**From:** Ewan Stewart  
**Sent:** 31 March 2022 09:31  
**To:** Linda Griffiths  
**Cc:** Planning  
**Subject:** 21/02083/REM Land At Tappers Farm Bodicote

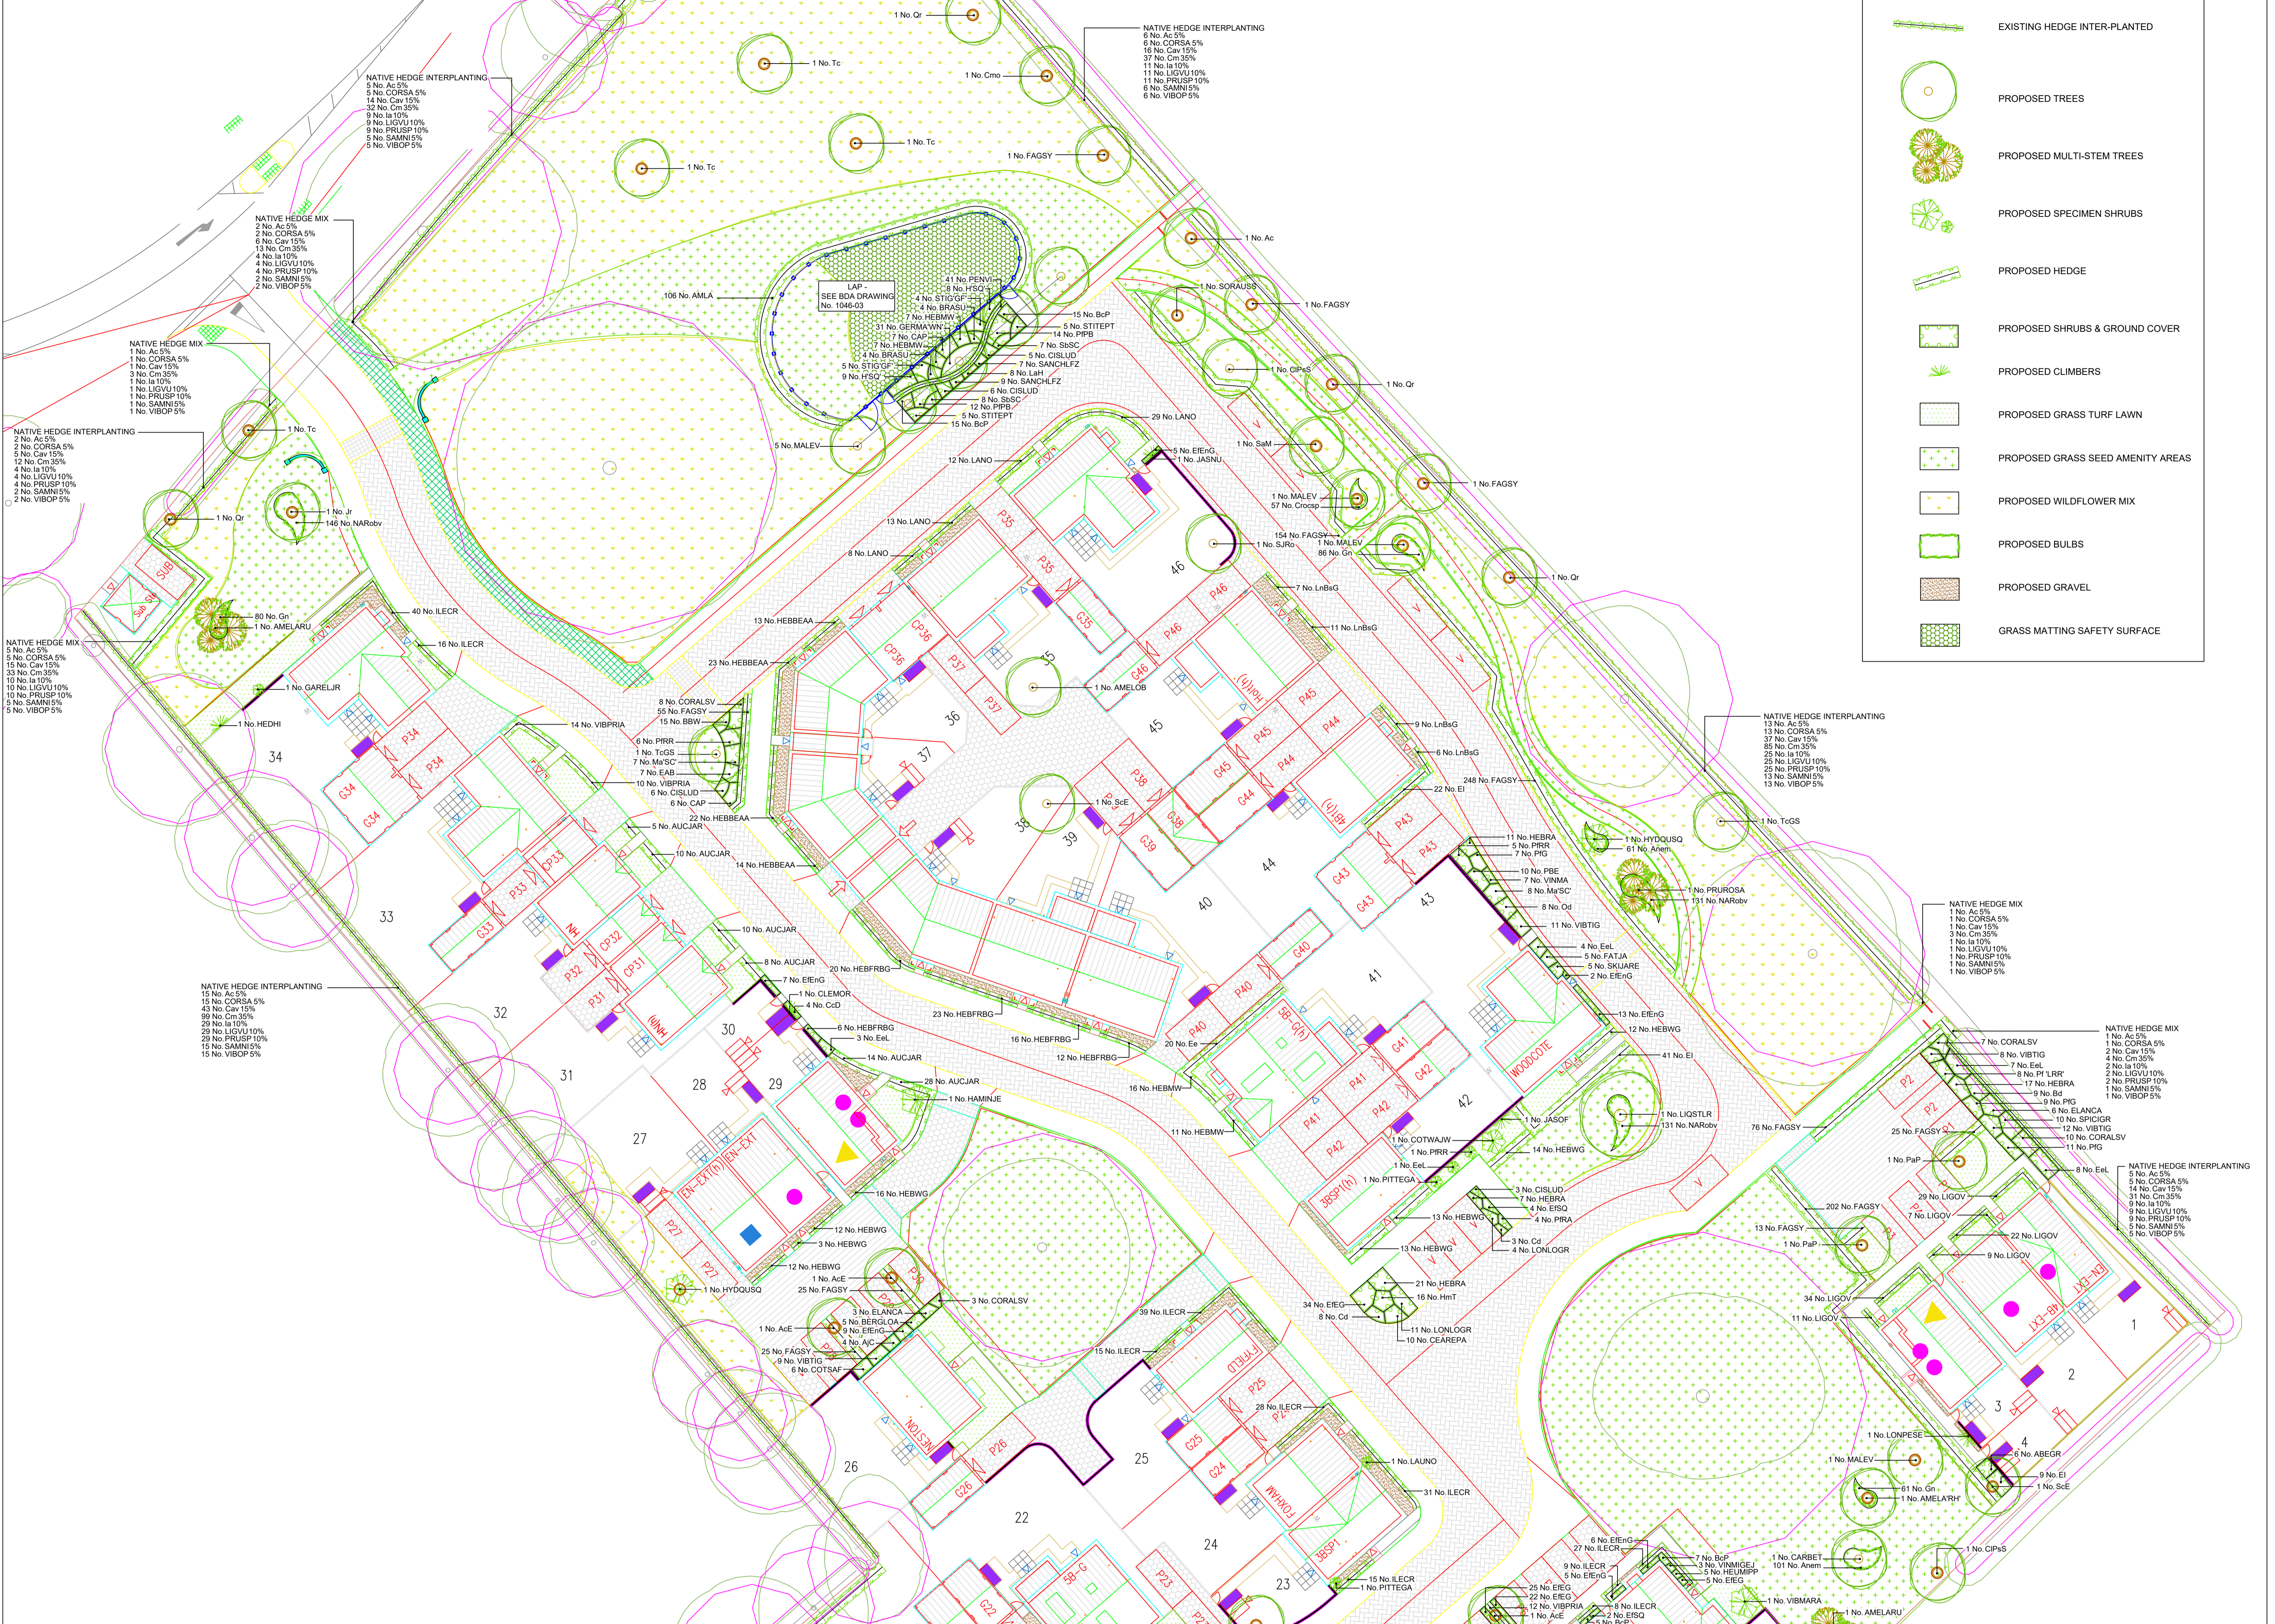
I have looked at the revisions to the above application and welcome the revised landscaping between the parking spaces for the affordable dwellings at plots 5 - 12 to provide sufficient space to allow for tree planting and other low level shrubs.

This helps considerably in addressing the issue I raised previously about the line of parking bays making the affordable dwellings stand out from the market dwellings.
